## CITY OF ALBUQUERQUE

RE: Sierra Sunset Park, 10600 Big Springs Rd. SW

**Grading & Drainage Plan**

Grading & Drainage Plan

SIERRA SUNSET PARK
GRADING AND DRAINAGE PLAN WEST

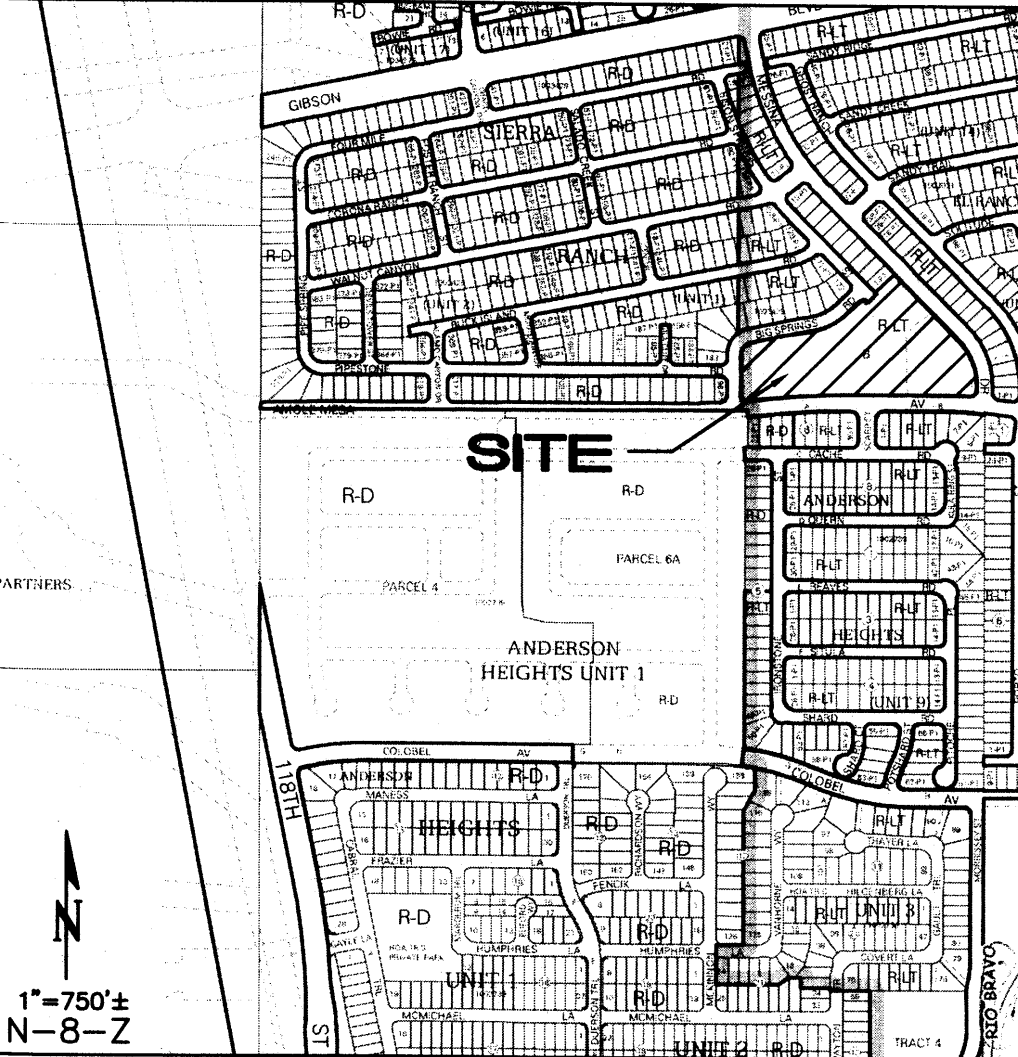
- AMAFCA must approve the plans before Building Permit approval can be granted.
- Indicate what keyed note 9 is.

- Show the existing contour elevations [values] so as to compare to the proposed contours.
- Bench mark information is missing in the title block.

- 3. The referenced Keyed note symbol 9 was a typo we will revise to '8' I believe you mean note 2 mowstrip
- 4. We will label the existing contour elevations
- 5. The architect has requested the benchmark from the surveyor. The surveyor (PAIKI) has responded that we should use the 'SURV-TEK Control point CP-52' shown provided on the survey. The following note on the survey references NAVD88. Will this work In order to compare the as-builts in the old datum, and the MWSEL from past study, we need to know the elevation of the survey monument off which the survey is based. Is this a new survey?

SIERRA SUNSET PARK GRADING AND DRAINAGE PLAN EAST

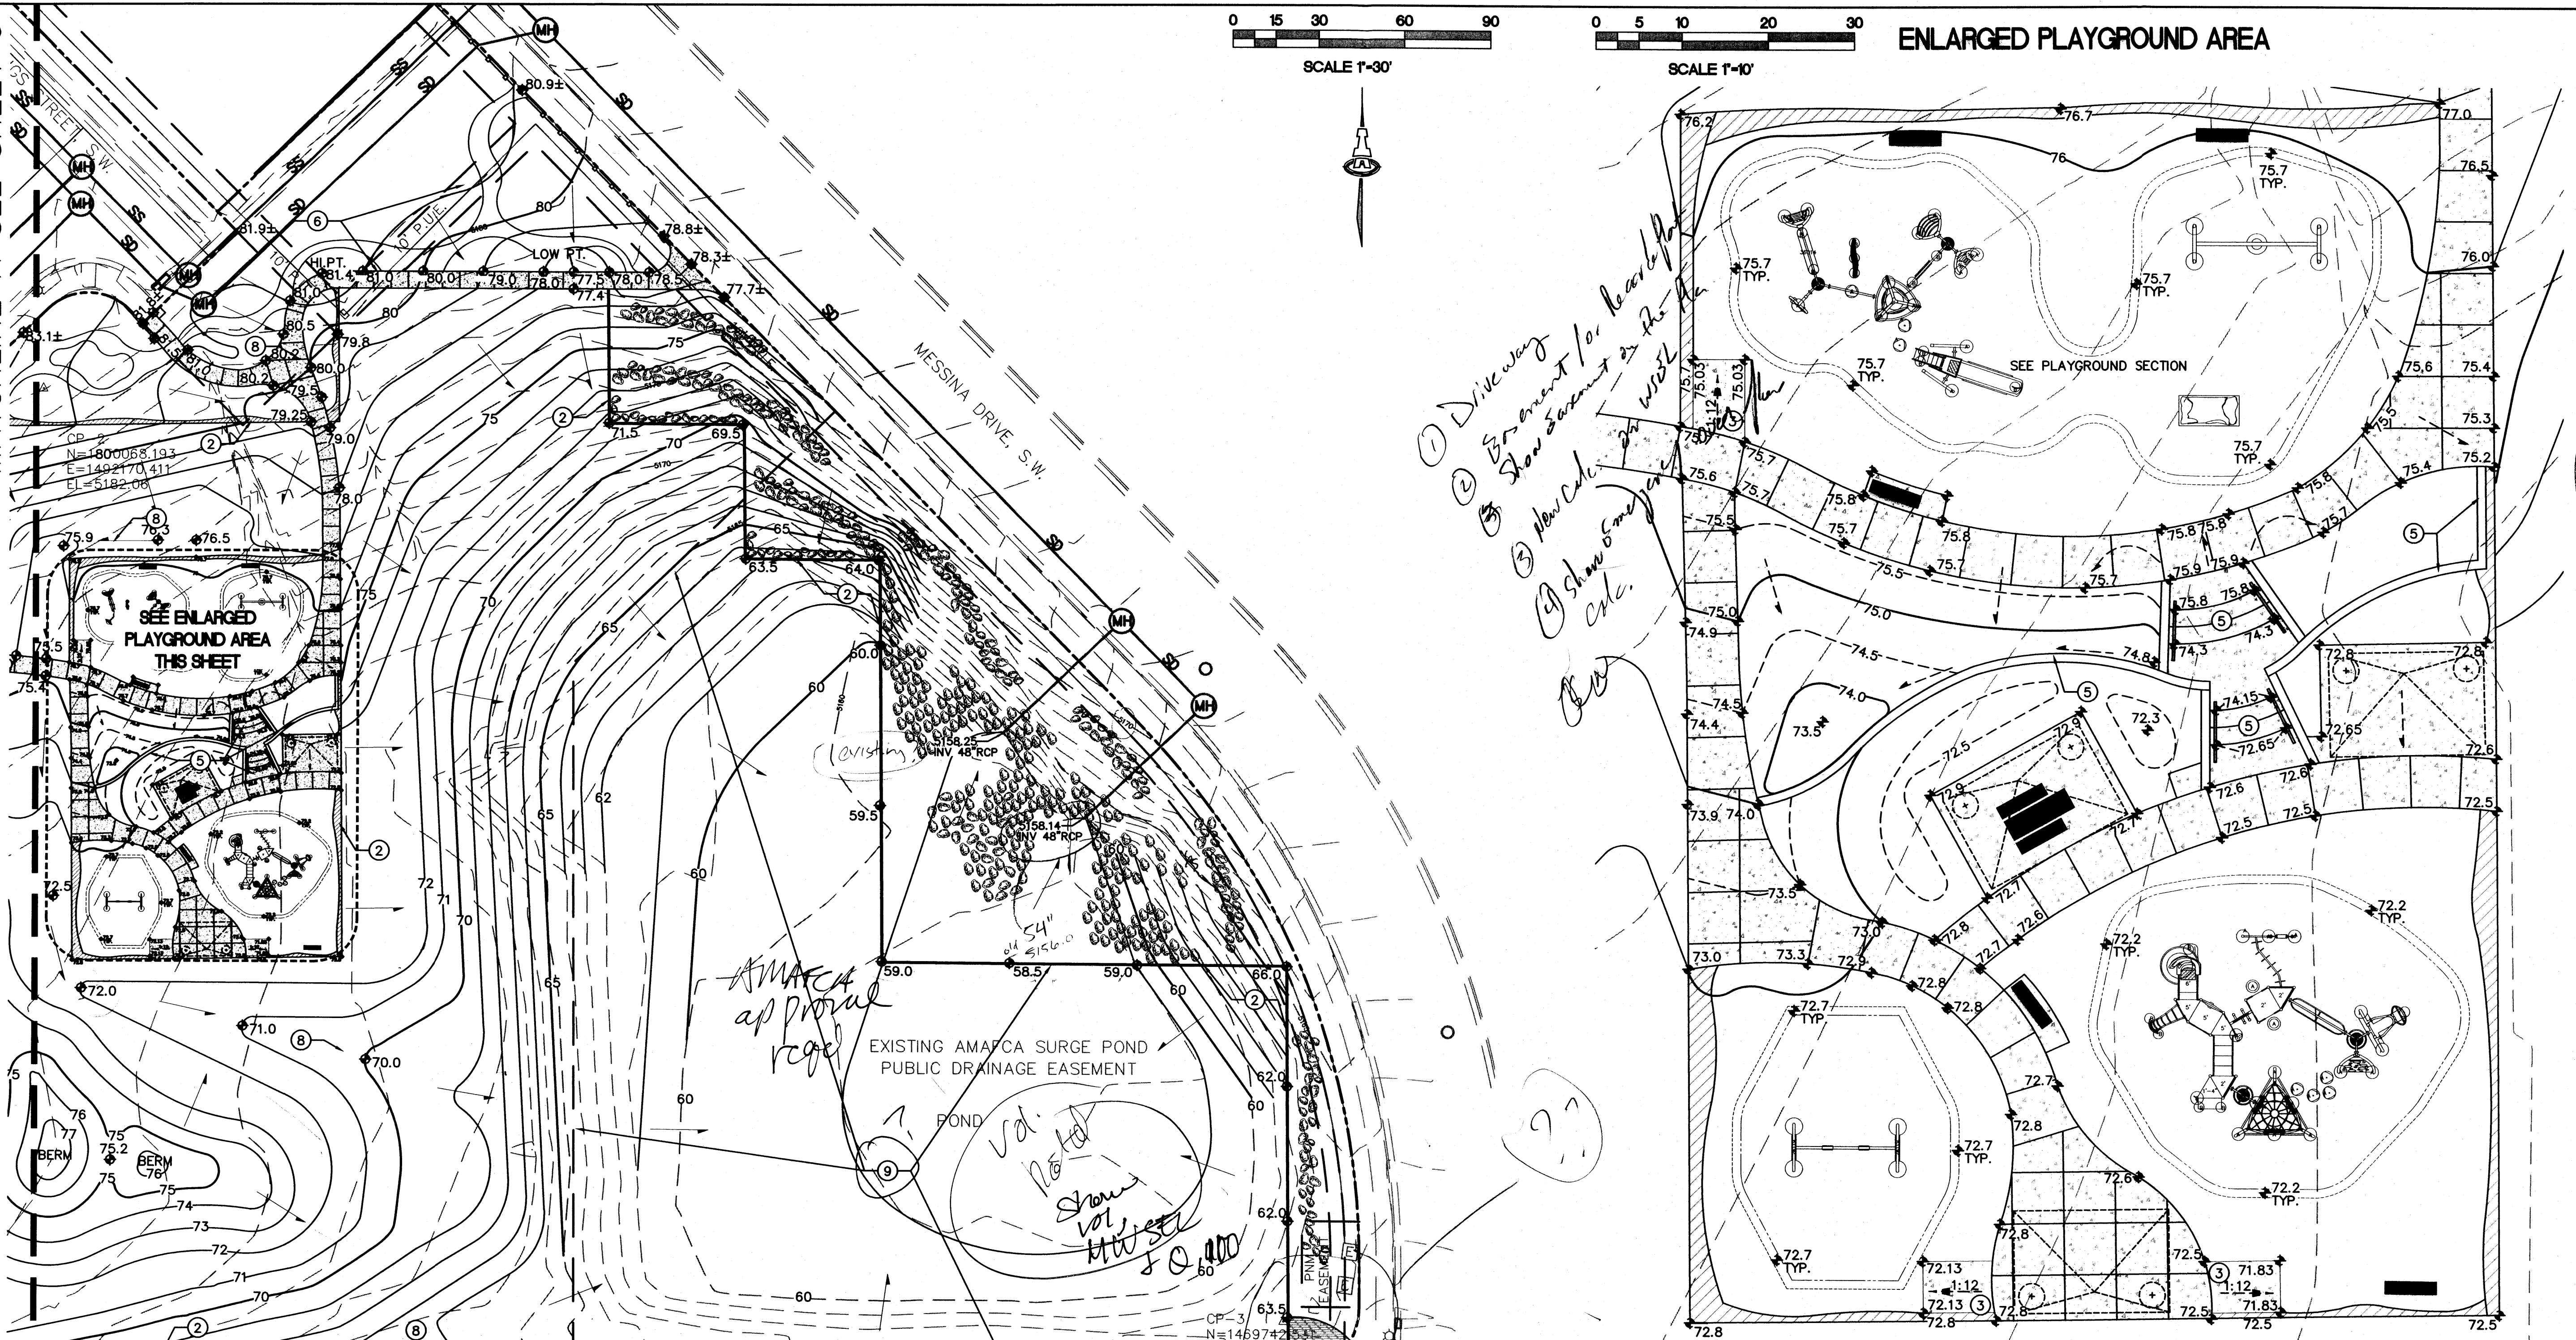
Other additional comments are that both storm drains are labeled 48", whereas one is a 54" SD. Also, keyed note 4 calls out an asphalt ramp. Have you checked with transportation for their sign-off on this?

Show volume, MWSEL, Q100 for the proposed pond. In the calculation of pond volume, account for the volume of the landscaping boulders that would decrease the pond capacity.

- 1. (see below)Looking at the Drainage Study for the Sierra Ranch Subdivision, the pond volume is 4.2 acre-ft, and the MWSEL is \$160.3 ft (old datum) which would be approx.. 5162.7 ft in new datum. Can you explain the discrepancy in the Pond volume (3500 CY = 2.17 Acre-ft)? The pond volume should be maintained. It seems calculations are in order showing the proposed pond volume, MWSEL, and Emergency Overflow calculations.
- 2. We submitted the plan to AMAFCA and received an email from Lynn Mazur that the surge pond is not an AMAFCA facility. We will eliminate the reference and label it PUBLIC DRAINAGE EASEMENT. AMAFCA will not be reviewing.

Regarding the pond: this surge pond was constructed in 2005 (see as-built below – different datum). In order to use this area for a park, we had to do some minor regrading to establish a slope which would accept sod (6:1). Other than that, we have not altered the pond grades significantly. Based on our preliminary volume calculations for the proposed condition, there is an available volume of 3,500 CY (top of water surface elevation \$161.7)) If the pond were to fill to this elevation, it would spill over at the existing low point and enter Amole Mesa Avenue. We will calculate the volume of the proposed boulders to account for displaced flow if necessary. We estimate approx. 160 boulders @ 2x3x3 with 1/3 buried which would be approximately 71 CY. Is there a specific design volume requirement for this surge pond? I would
